Office and Warehouse

1240 Valley Street
Colorado Springs, CO 80915

Project Number : 25014
Project Phase: SDP
Drawn by : RSH
Drawing Date : 29 July 2026

CS
Cover Sheet

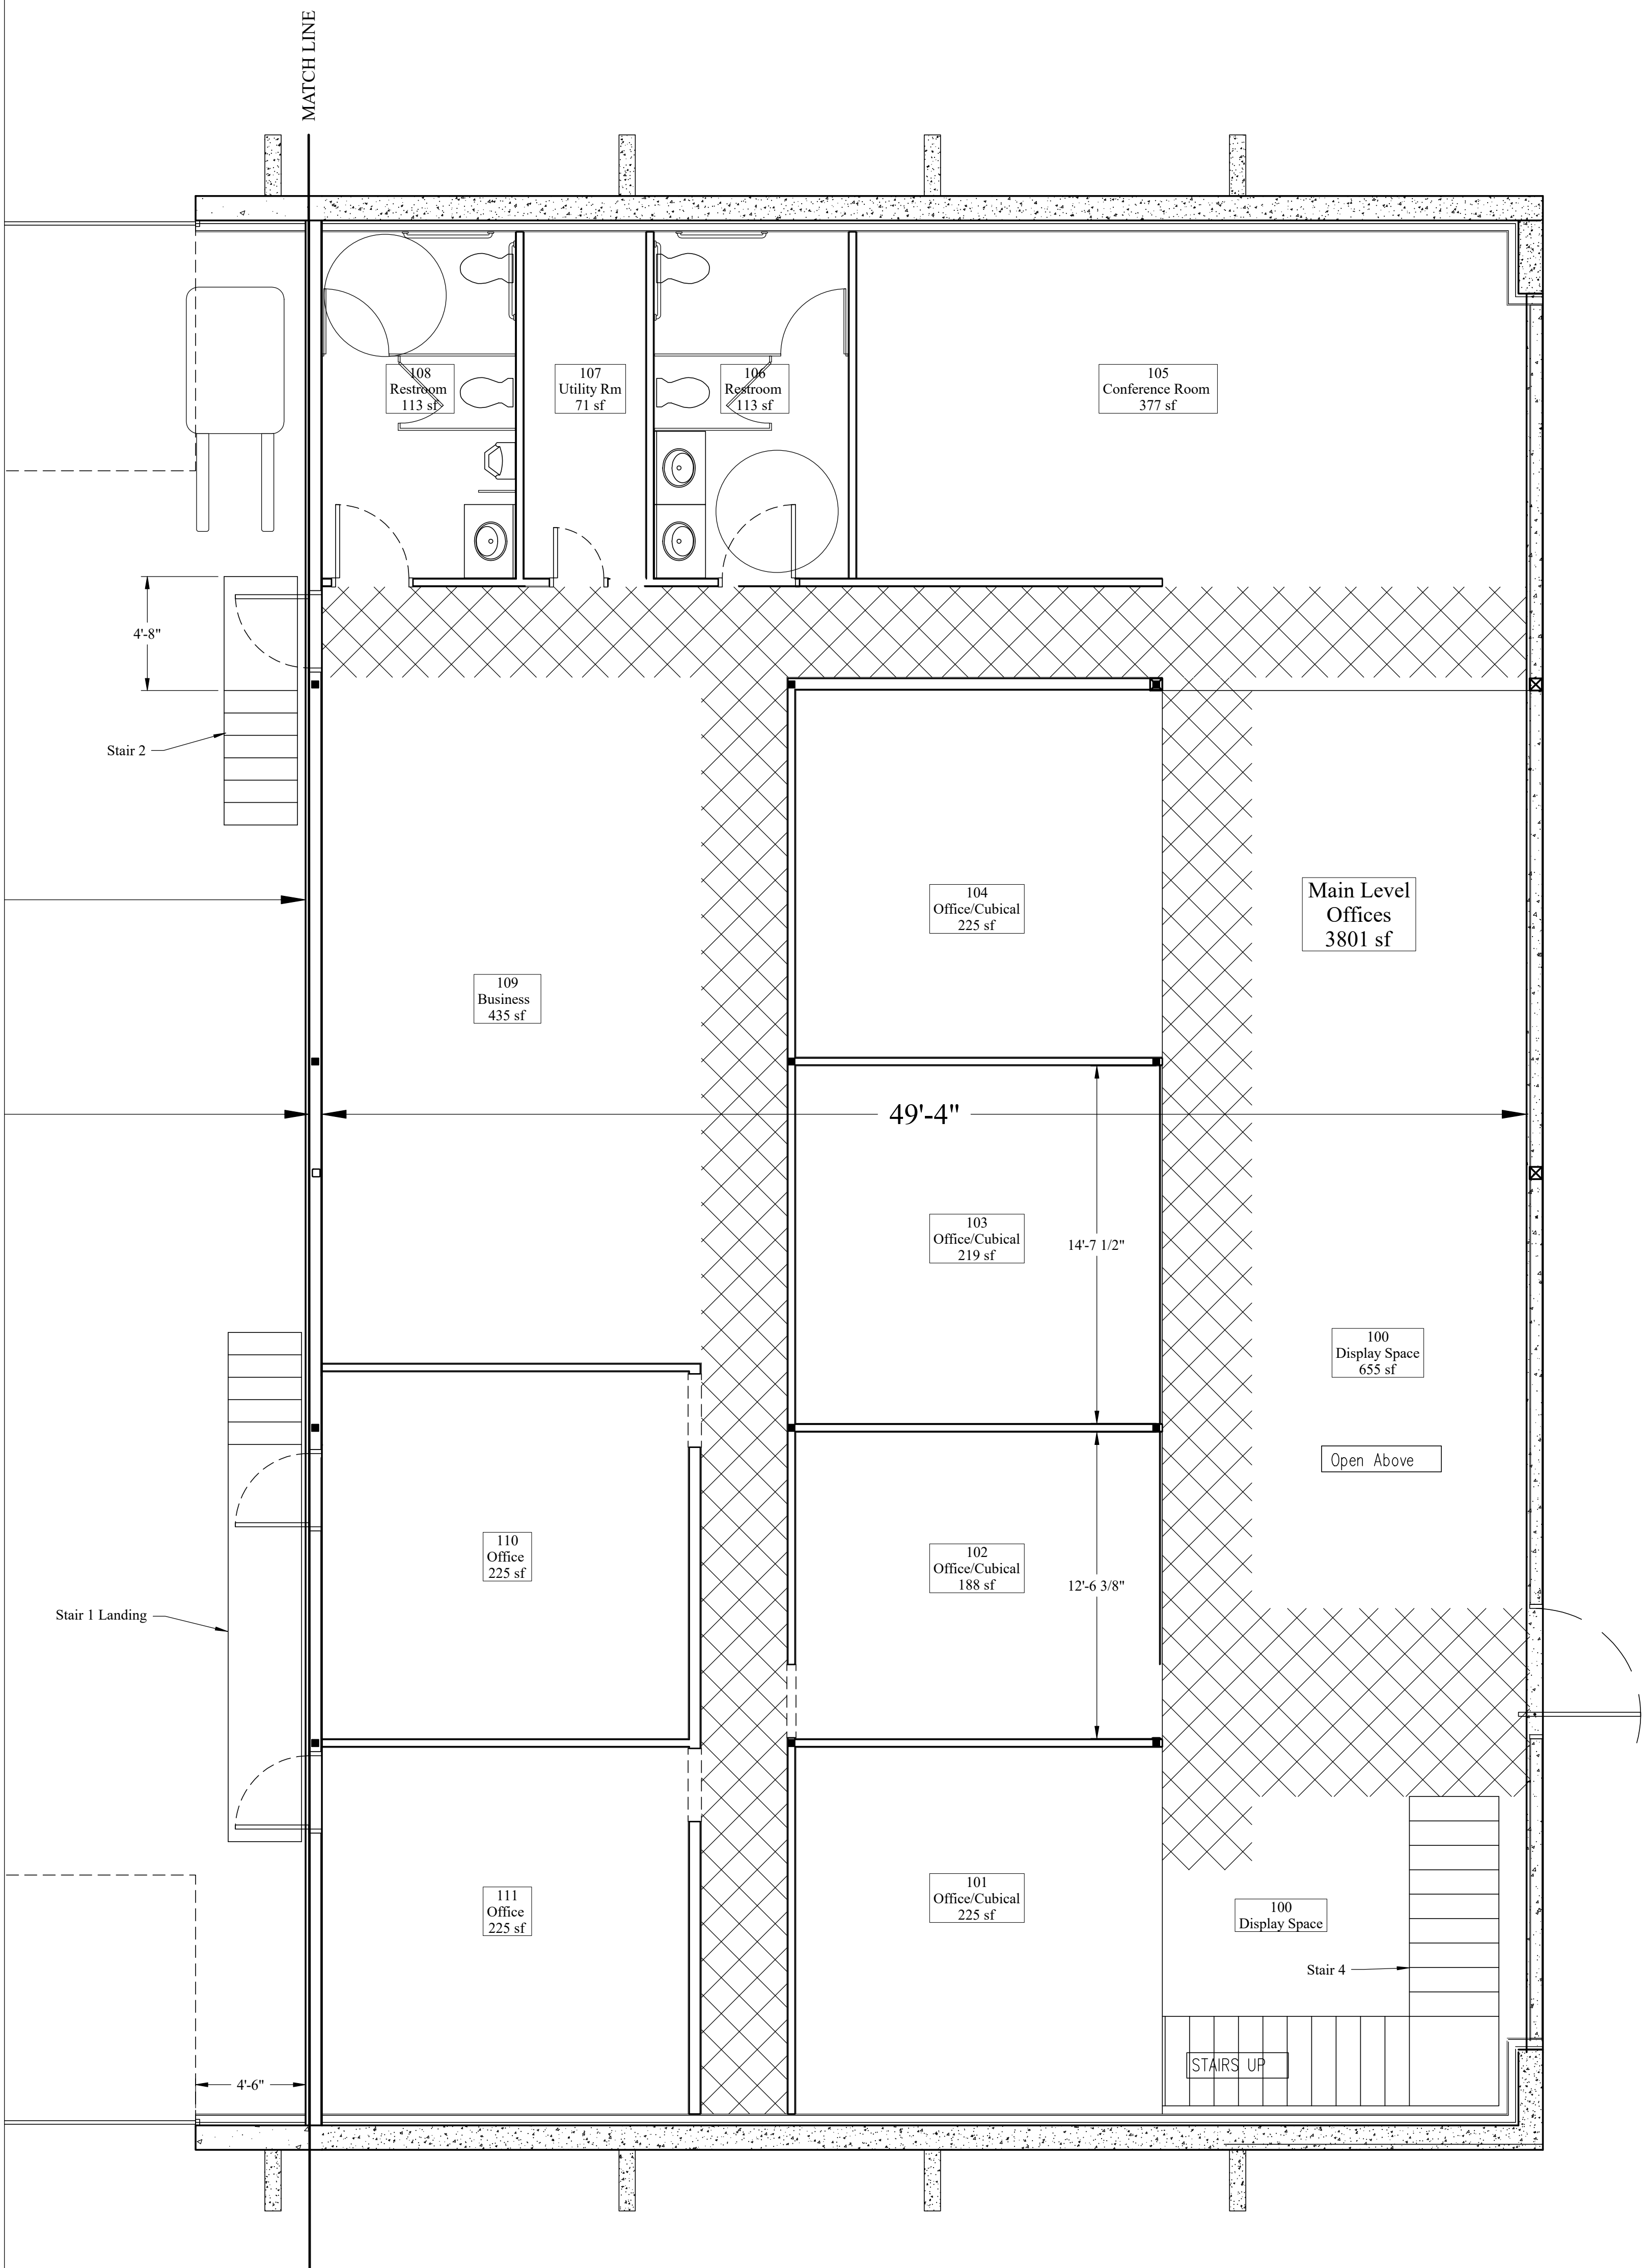
New **Bldg** = 14,640 sf (excluding buttresses and facade bumpouts)
 New **Total Building Floor Area** = 17,018 sf
 Building **Footprint Area** = 15,937.5 sf (includes buttresses and facade bumpouts)
 Lot Coverage = **34.2%**
 Disturbed Ground = **42,546 sf**
Please include the height of the building
IMPERMEABLE SURFACE AREAS
 Concrete/Pavement = 14,040 sf
 Roof = 14,640 sf
 Impermeable % = 61.1 %

SP 1
Preliminary
Site Plan

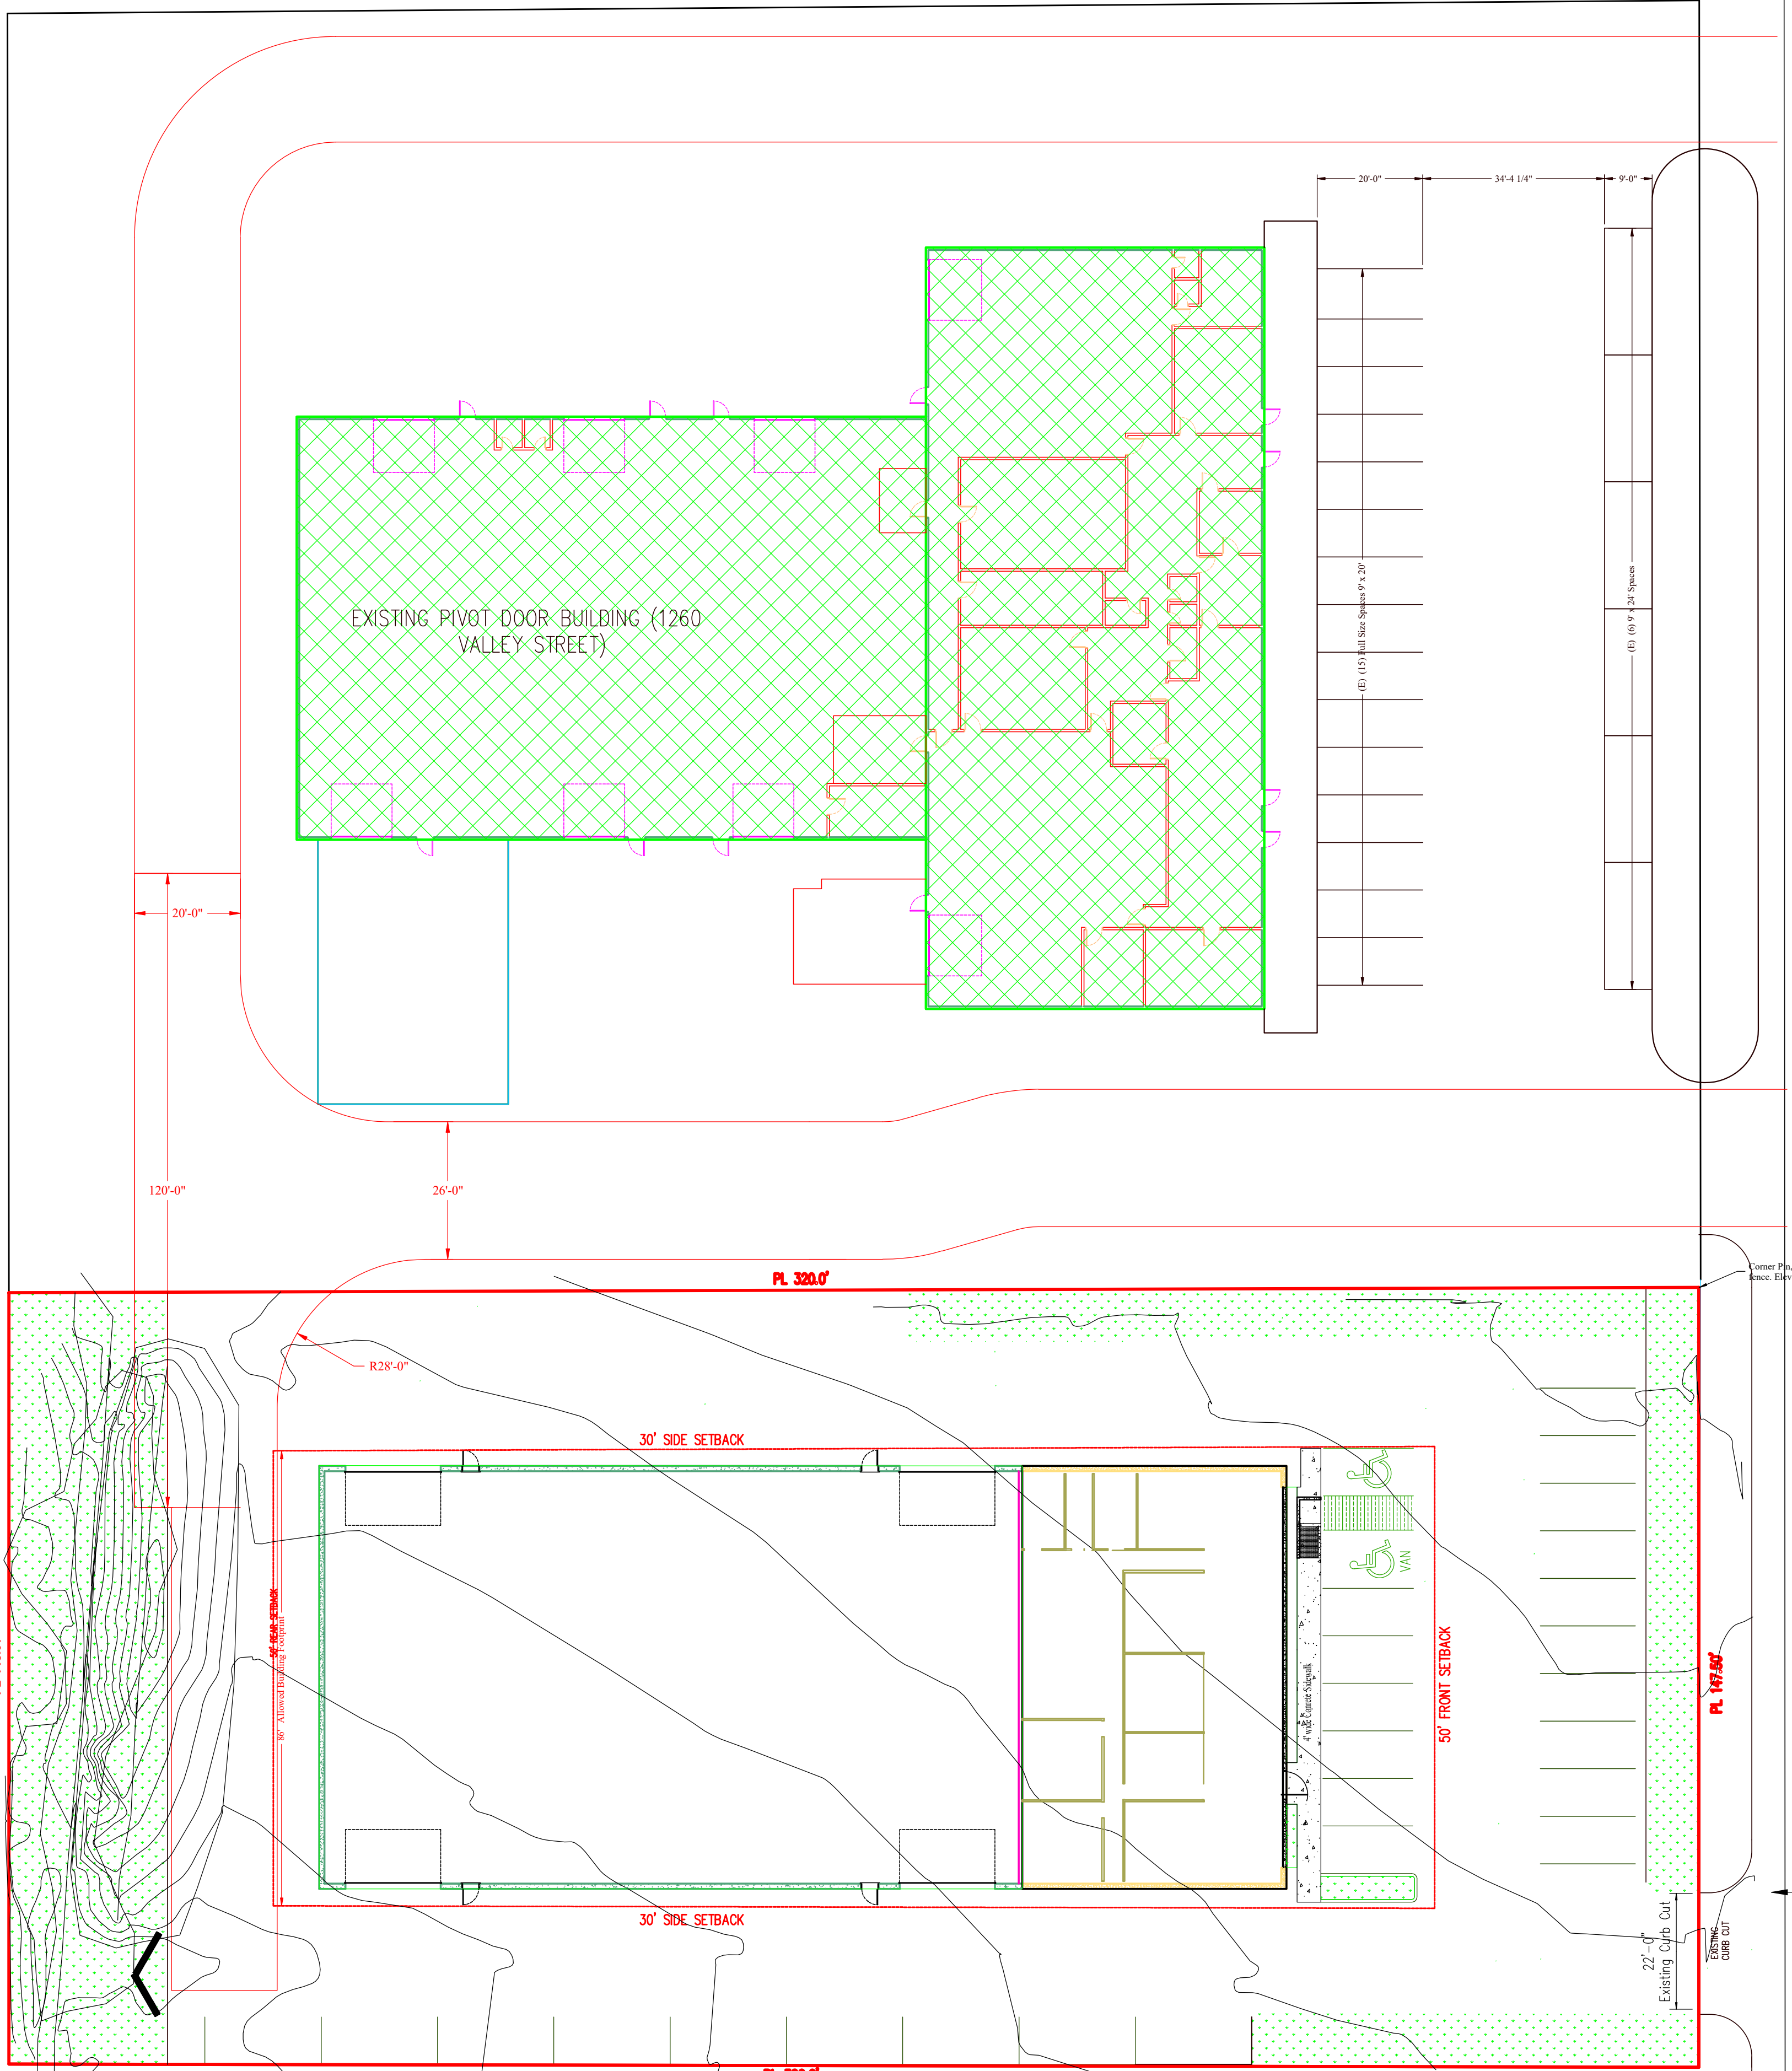
Please label the curb cut to close and provide CDs for the curb and gutter work.

Off-site disturbance should be included in your overall disturbed area

The site map makes it look like there is closer to 38,000 sf of impervious area. What might help clarify this is hatching or labels identifying the different proposed surface types (like what's shown on the grading plan). All gravel, roof, and pavement area would be considered impervious.

- include hatching or delineation of new pavement

Valley St has 60' of ROW; please include roadway classification

minimum width is 25' for two-way commercial or industrial accesses. 15' may be used for one-way access.
